Re: NMCC Proton Therapy Expansion Project
4901 Lang Ave. NE
Traffic Circulation Layout
Engineer's/Architect's Stamp XX-XX-XX (D17-D003V1)

Based upon the information provided in your submittal received 4-22-22, the above referenced plan cannot be approved for Building Permit until the following comments are addressed:

TRAFFIC CIRCULATION LAYOUT

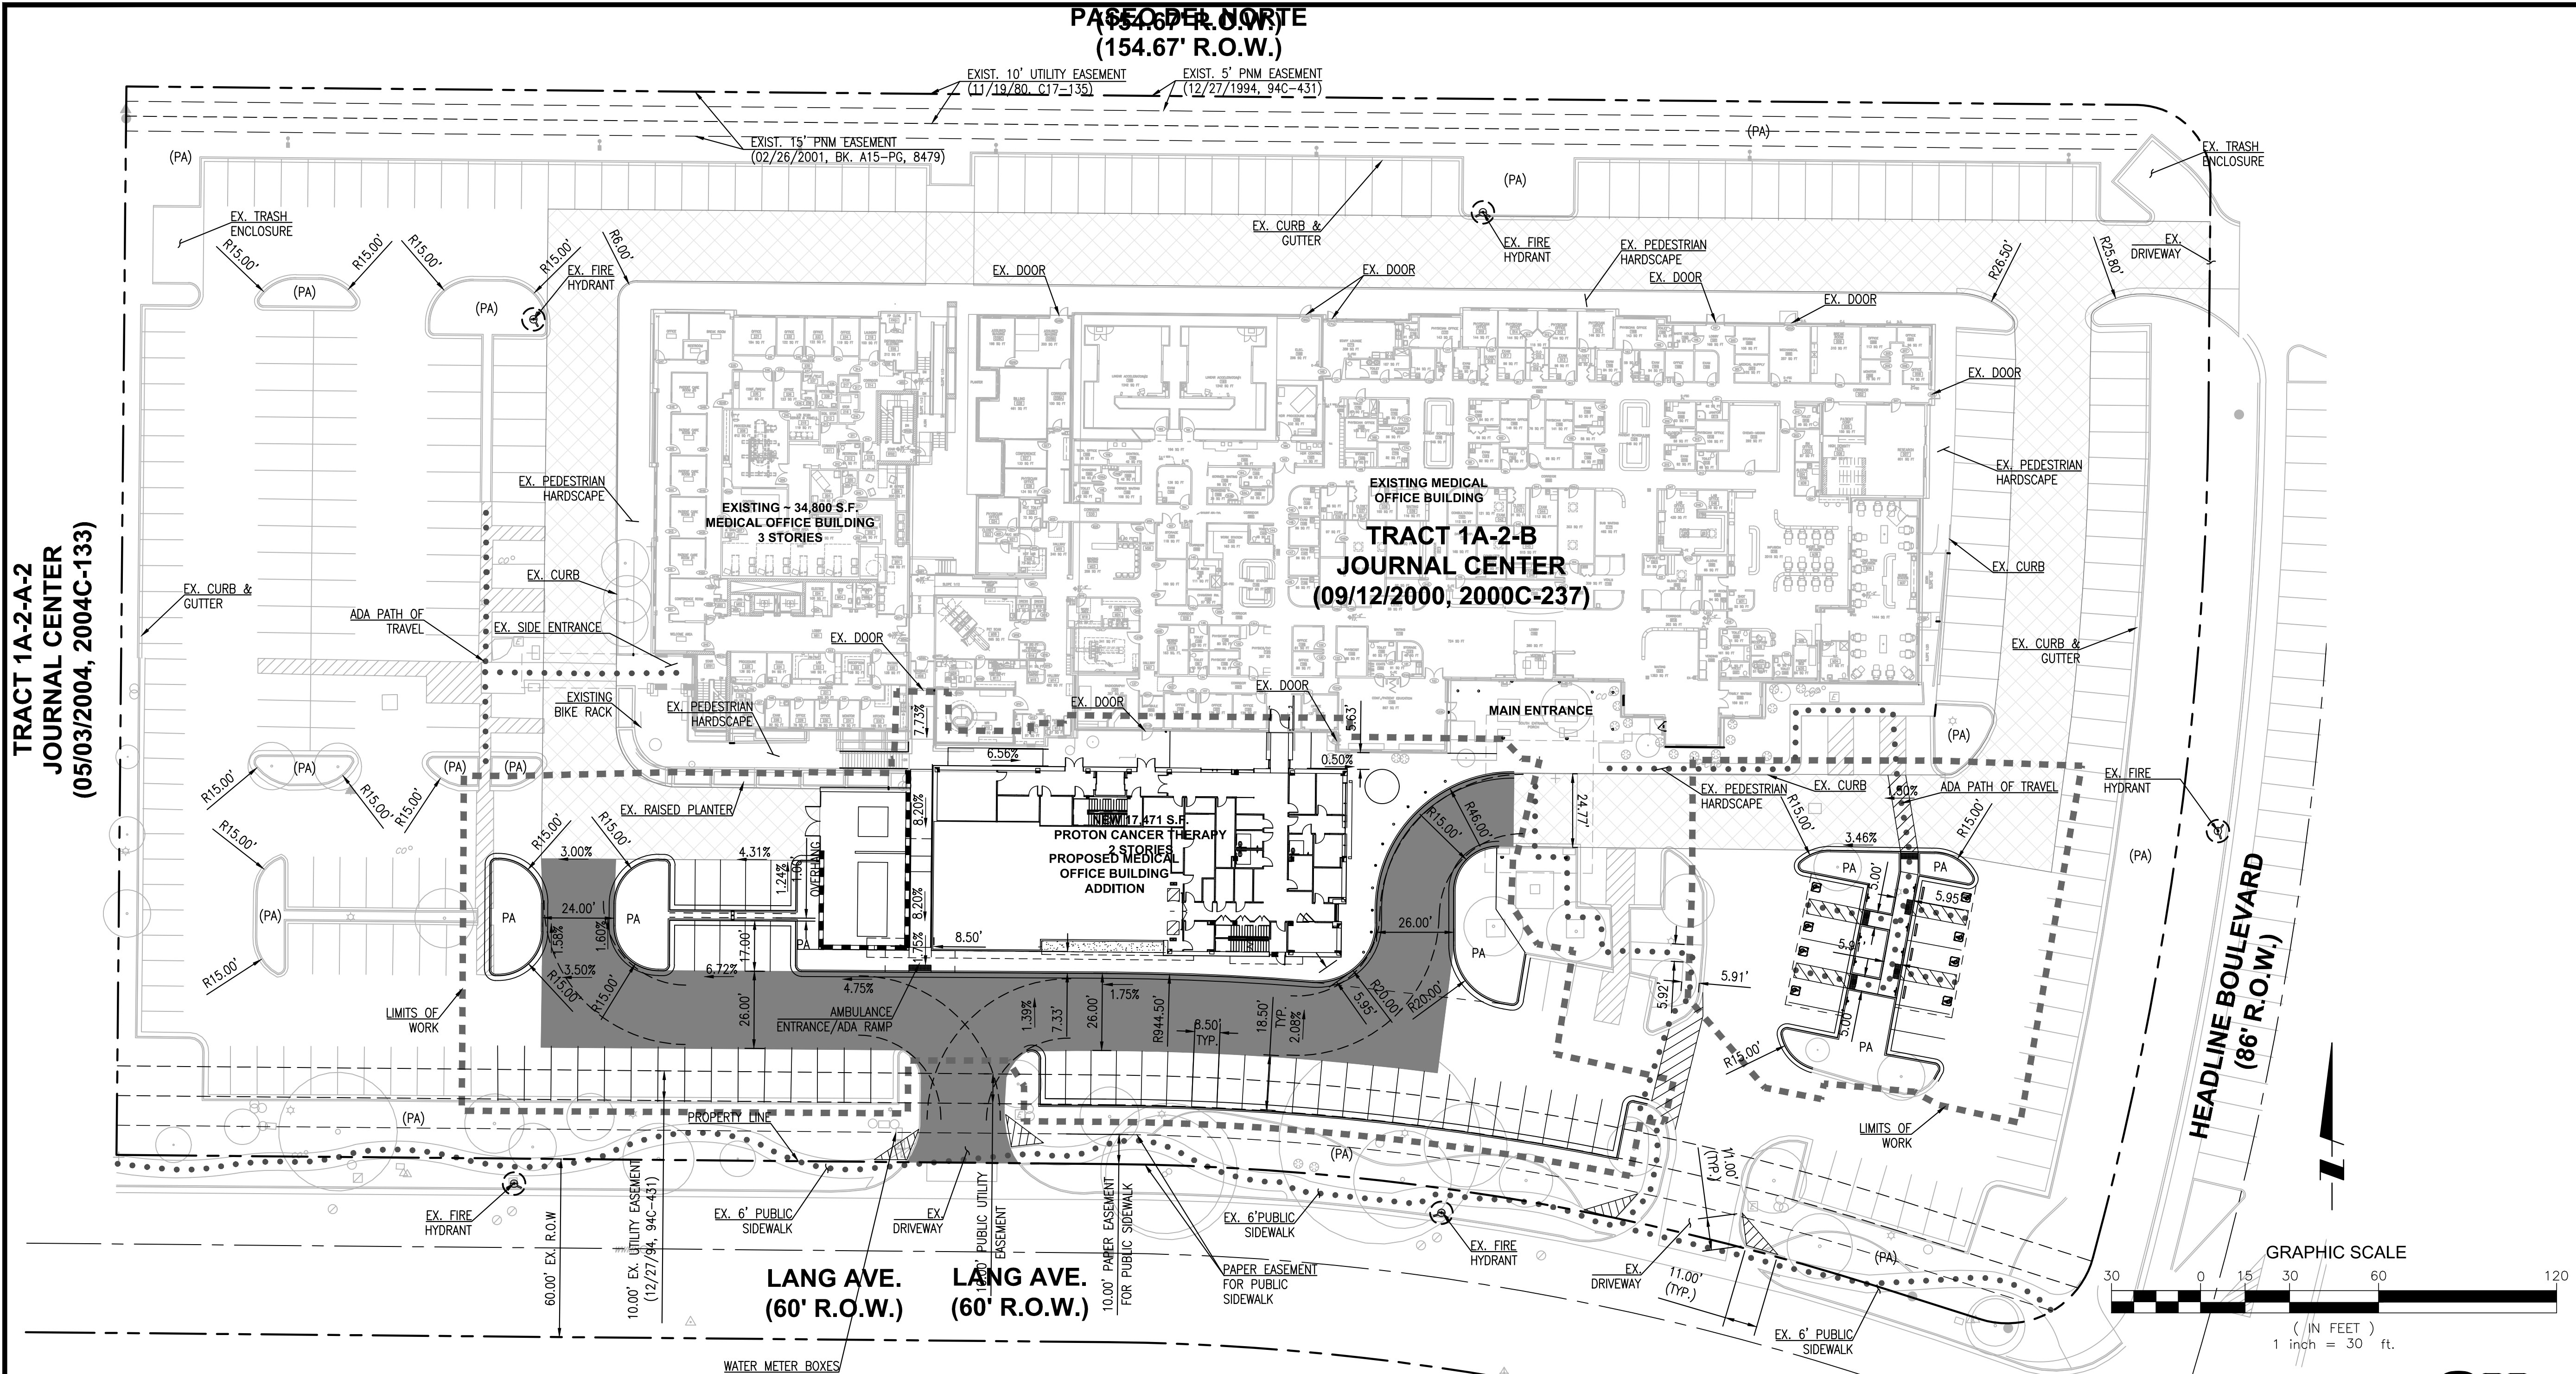
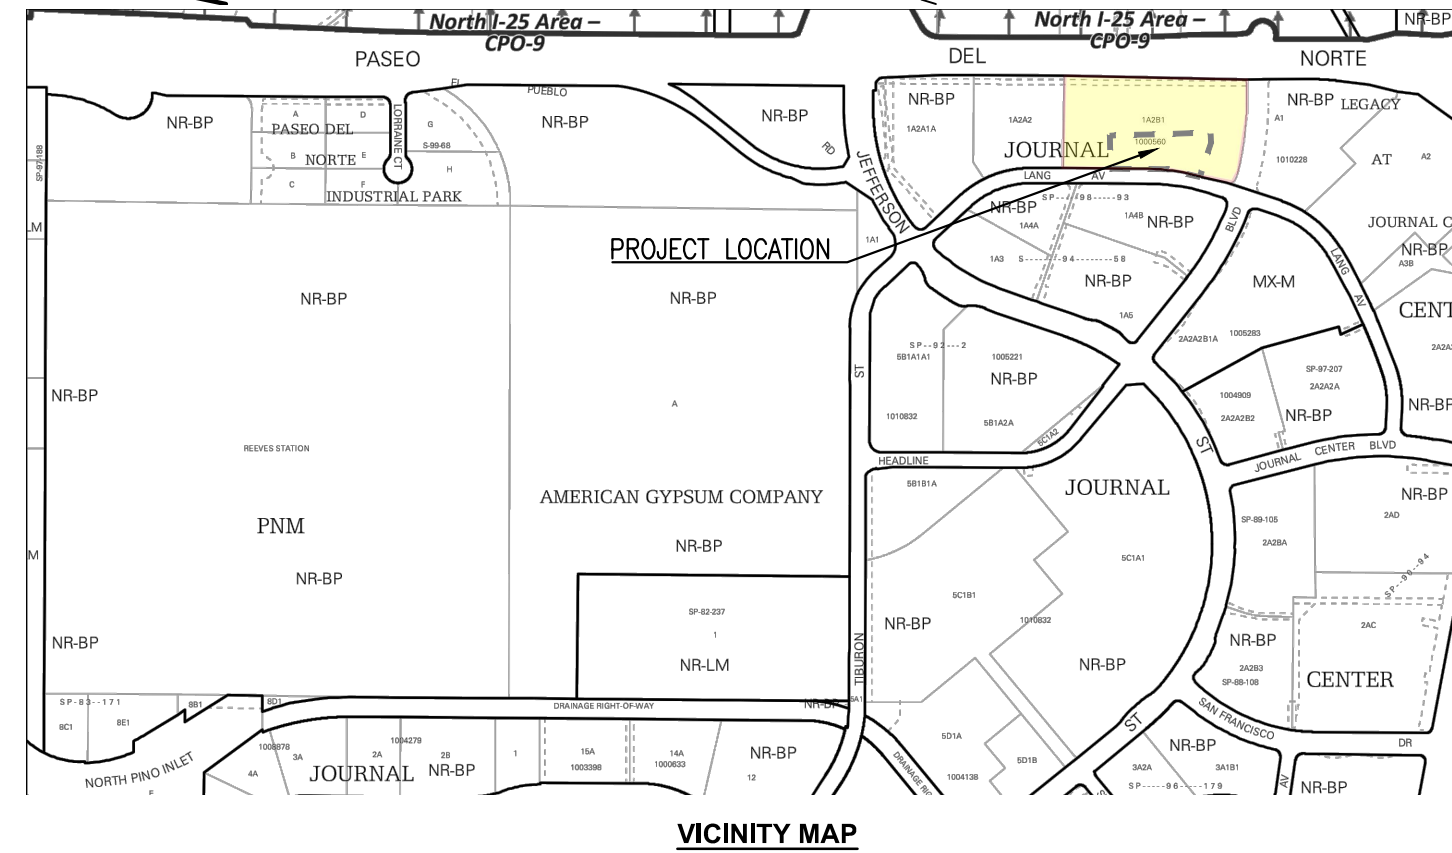
1. Include bicycle and motorcycle parking in the List of parking spaces required by the IDO
2. The traffic circulation layout must be stamped, signed, and dated by an engineer or architect licensed in the state of New Mexico.
3. Provide details for the proposing ramps.
4. Provide the width for the existing driveway accesses for Lang Ave.
5. Please list the width and length for all existing and proposed parking spaces. Some dimensions are not shown.
6. The minimum parking stall dimensions are:

7. Label the compact parking spaces by placing the words "**COMPACT**" on the pavement of each space.
8. The ADA accessible spaces must include an access aisle. Van accessible aisles should be 8ft wide; all others should be 5ft wide.
9. The ADA accessible parking sign must have the required language per 66-7-352.4C NMSA 1978 "**Violators Are Subject to a Fine and/or Towing.**" Please call out detail and location of signs. Provide Face sign details.
10. The ADA access aisles shall have the words "**NO PARKING**" in capital letters, each of which shall be at least one foot high and at least two inches wide, placed at the rear of

11. ADA curb ramps must be updated to current standards and have truncated domes installed.
12. Motorcycle parking spaces shall be designated by its own conspicuously posted upright sign, either free-standing or wall mounted per the zoning code.

17. Show all existing drive aisle widths and radii. Some dimensions are not shown.
18. Per the IDO, a 6 ft. wide ADA accessible pedestrian pathway is required from the public sidewalk to the building entrances. Please clearly show this pathway and provide details.

19. Per DPM, a 6 ft. wide ADA accessible pedestrian pathway is required from the ADA parking stall access aisles to the building entrances. Please clearly show this pathway and provide details.

20. Define ADA Pathways by labeling of ramps, flush pavement, dimensioning of pathway, and show the doorways on site plan.
21. ADA accessible pedestrian pathway should not be placed behind parking space or adjacent to a vehicular way. Vehicle and pedestrian/wheel chair conflicts should be avoided as much as possible.

25. Please provide a sight distance exhibit
26. Show the clear sight triangle and add the following note to the plan: "Landscaping and signage will not interfere with clear sight requirements. Therefore, signs, walls, trees,
